Referral Point : Simon Davis / Planning Officer – seeking advice on a planning application for the provision of additional parking spaces to a scheme which is almost completed out on site.

Reference : AW/139/14/DOC

Location : Land formerly the site of St Michaels & All Angels Church, Queens Fields, Aldwick

Tree Protection Plan

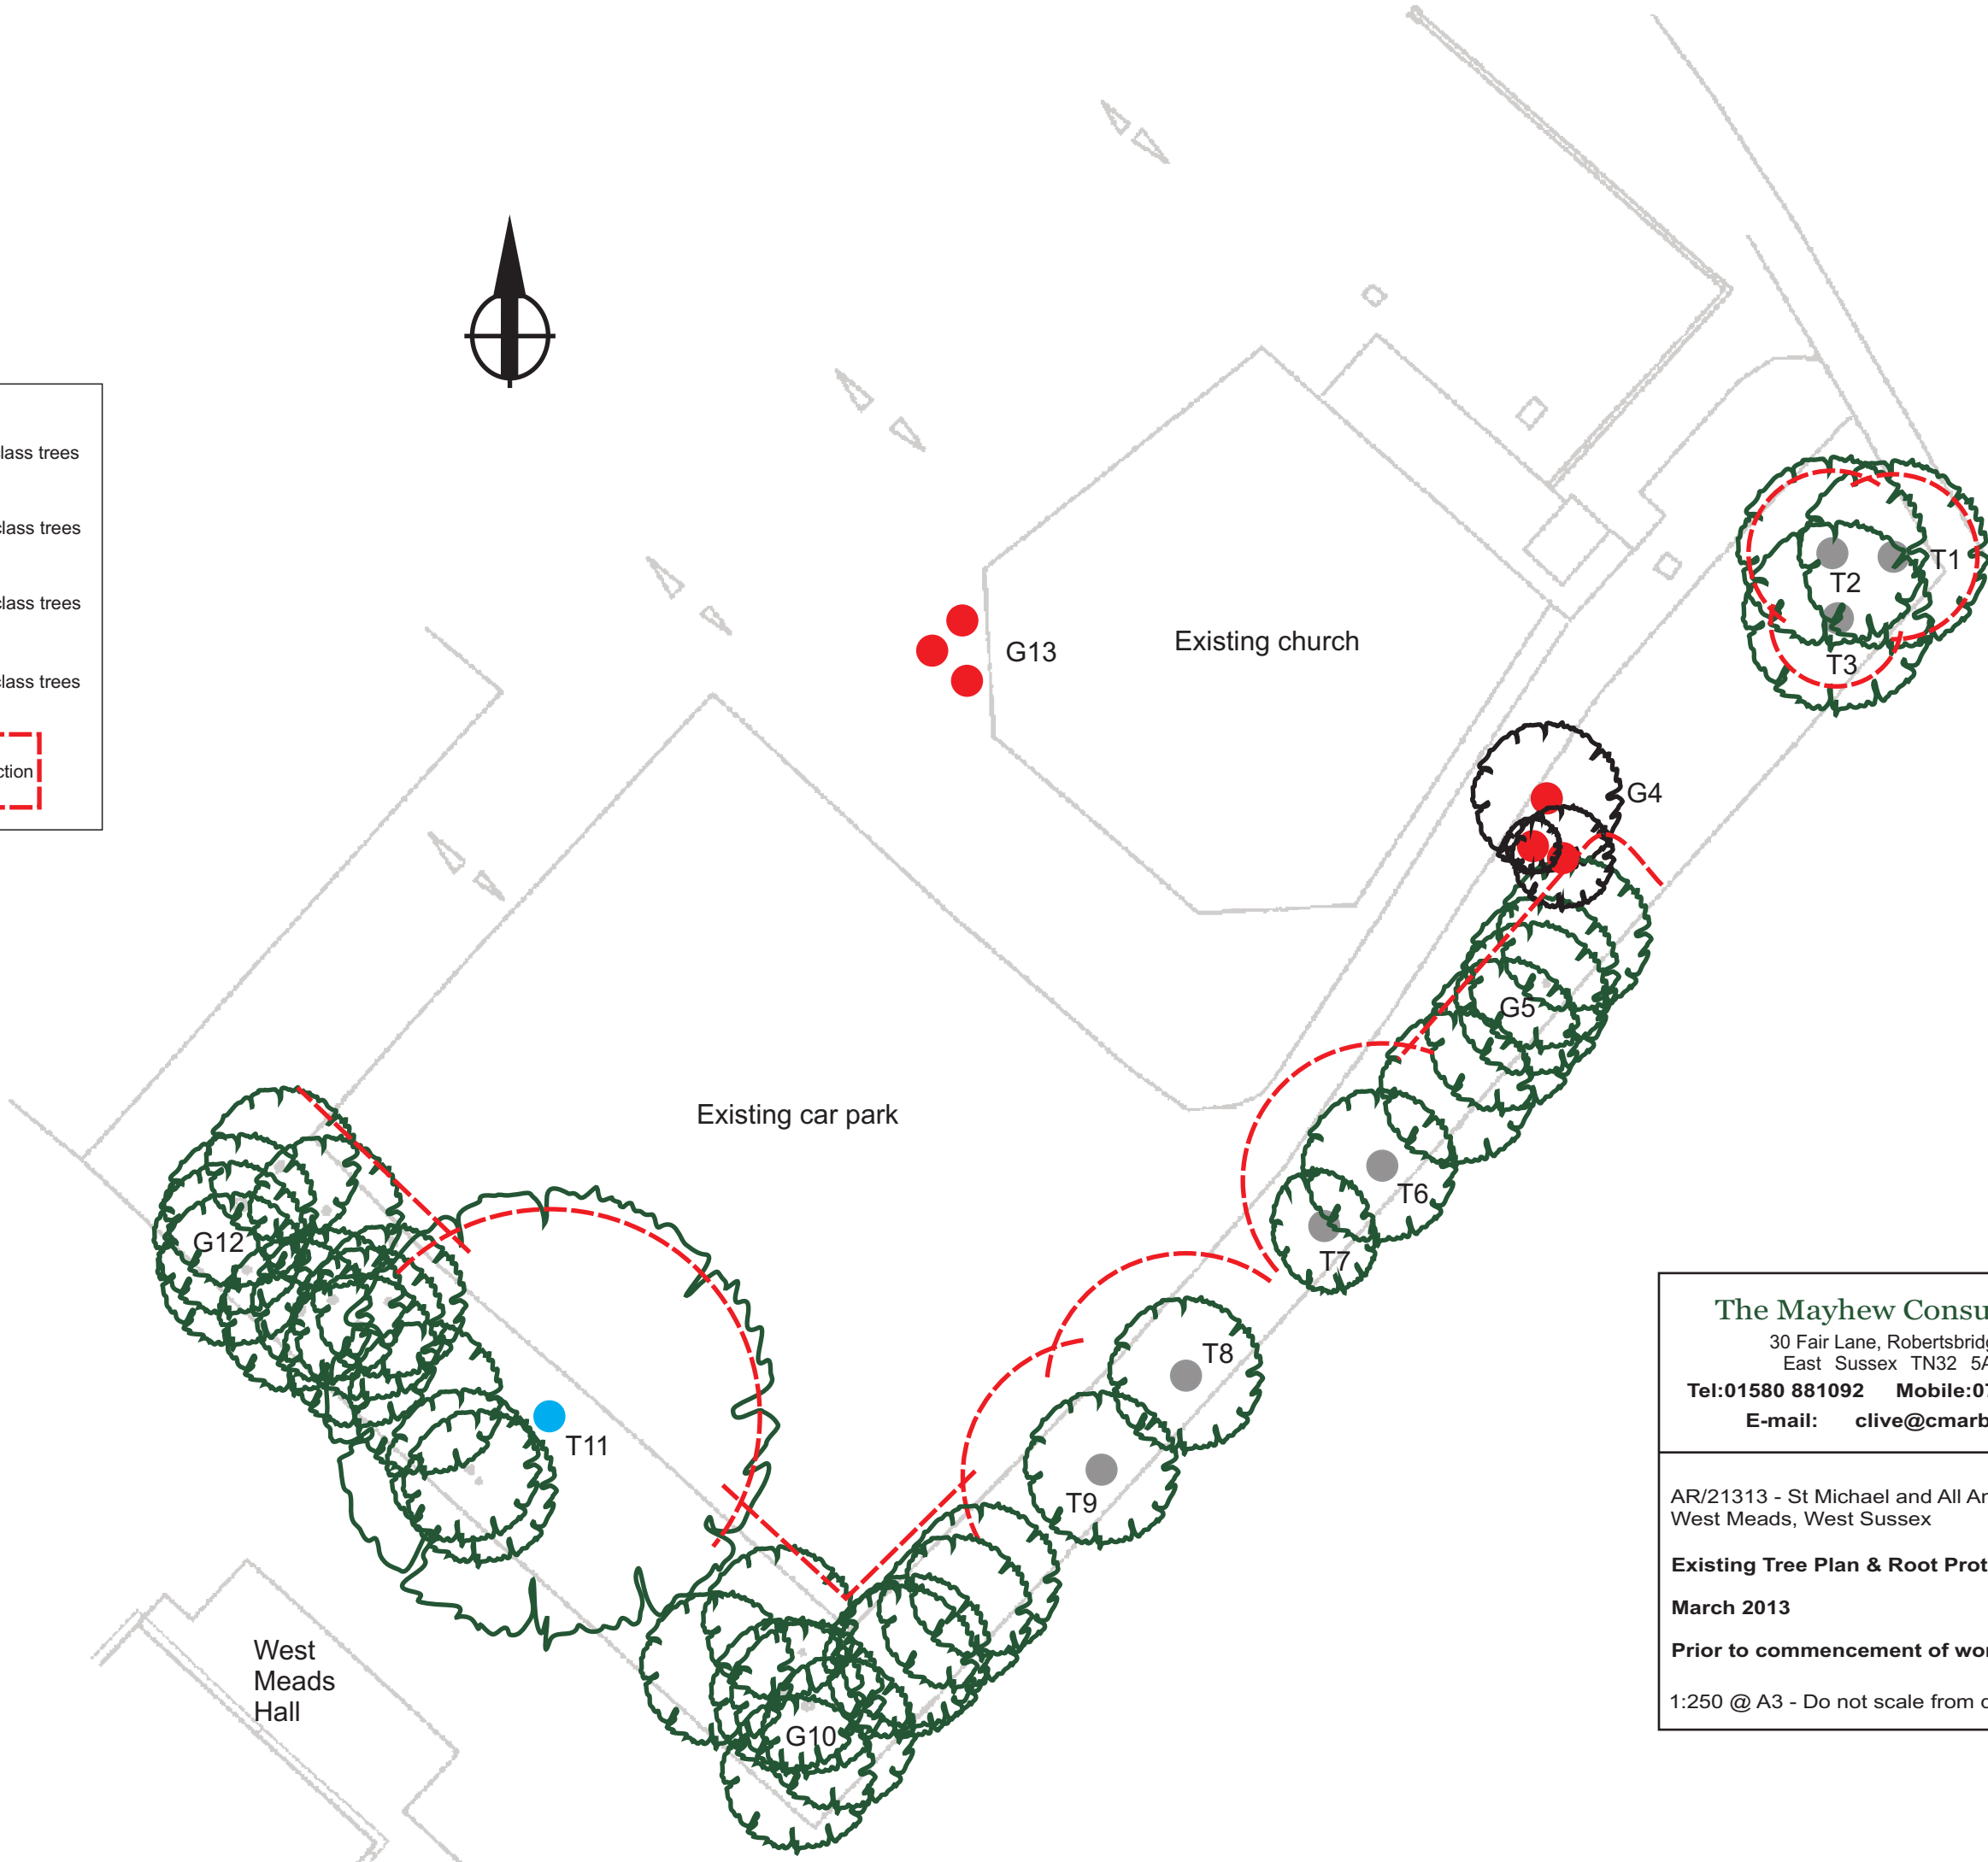
My latest site visit only confirms this – I saw evidence of compaction all around the new building and an excavator parked on the ground which The Mayhew report specifies should receive ground protection within the RPA of the London Plane T11.

Whilst I am therefore happy with the level of Arb input in respect of reports submitted I am less than satisfied with the fact that no site supervision and monitoring has been Conditioned and thus the developers have already done the damage and this is simply ‘ticking a box’.

The applicants have employed The Mayhew Consultancy who have prepared a good Arboricultural Impact Assessment Report covering the protection of these trees and I would be happy with this provided that their report is made the subject of a Planning Condition such that the developer is obliged to comply with its recommendations and furthermore employ Mr Mayhew to come out and supervise the installation and monitoring of the protective measures.
